Block Plan

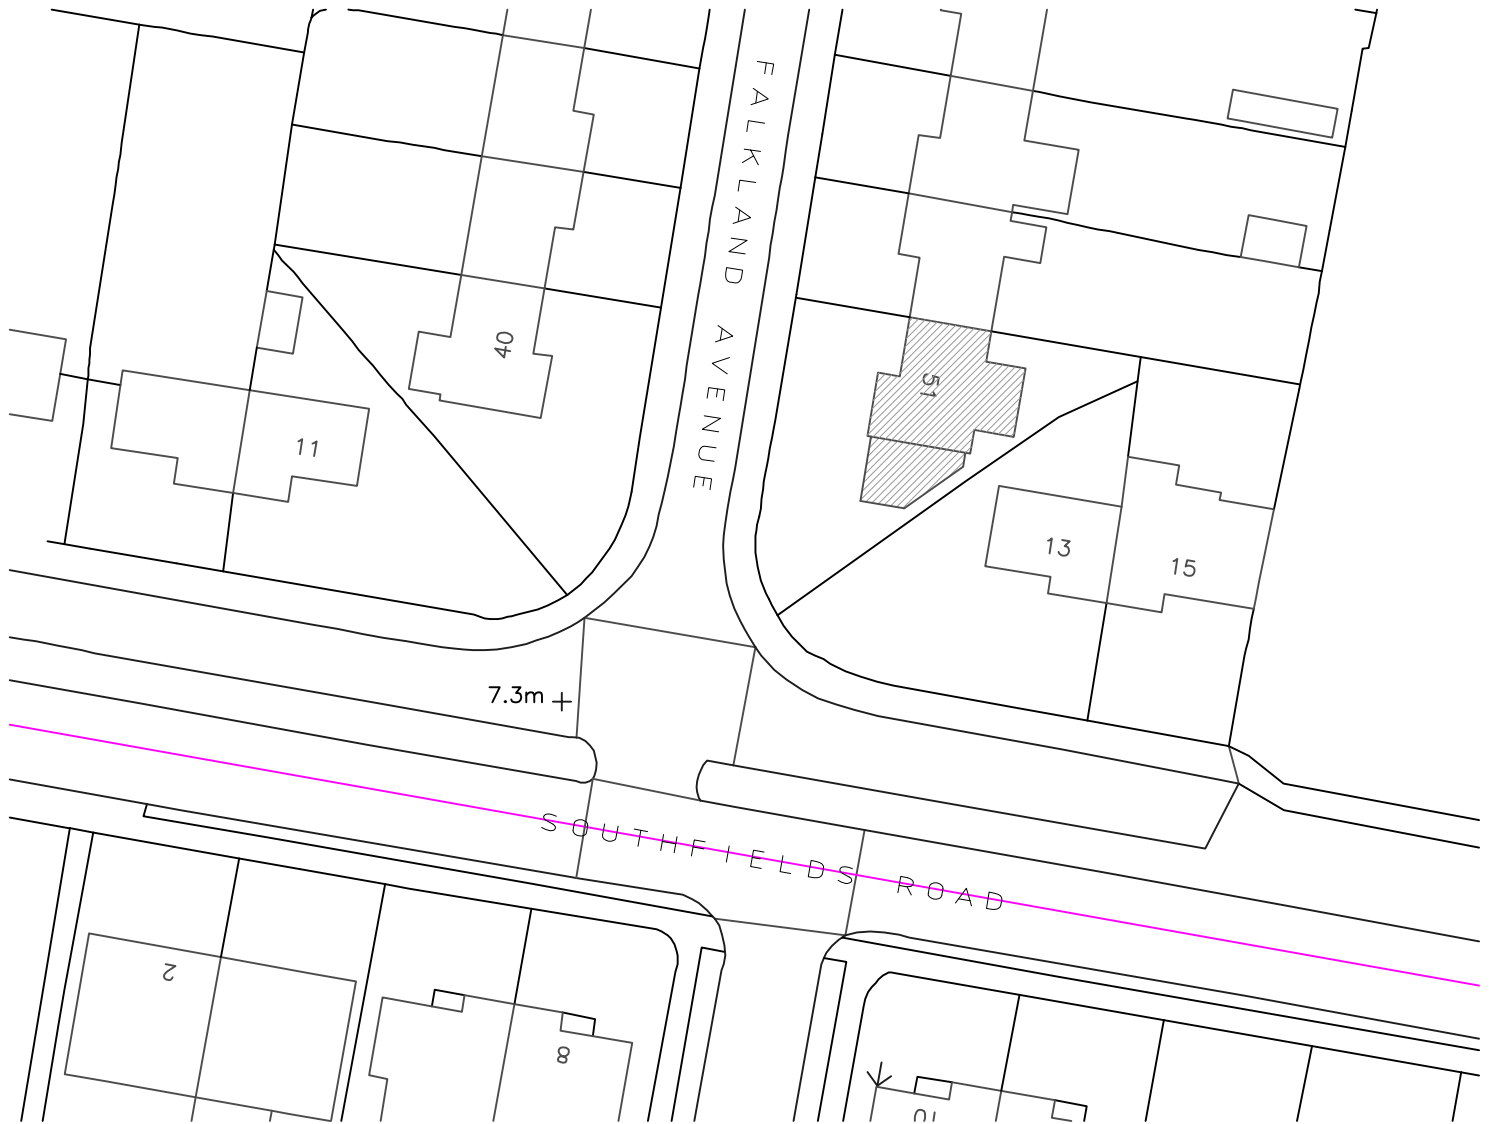
Please find the Highway comments attached. They are not objecting but do recommend a few conditions. One thing they would like changed is in terms of access, outlined below:

‘Access
This proposal includes construction of two additional vehicle crossovers (VCO) to accommodate the proposed parking provision. I have consulted the Area Manager to provide their comments in relation to the proposed VCO. They have advised that rather than two separate VCOs, the full height kerb between the two proposed VCOs should be dropped, providing a wider, shared VCO. Any access works onto the public highway must be constructed under a licence obtained from WSCC Highways to a specification agreed with them’.

Could you send in an amended plan incorporating this wider single vehicle crossover please?
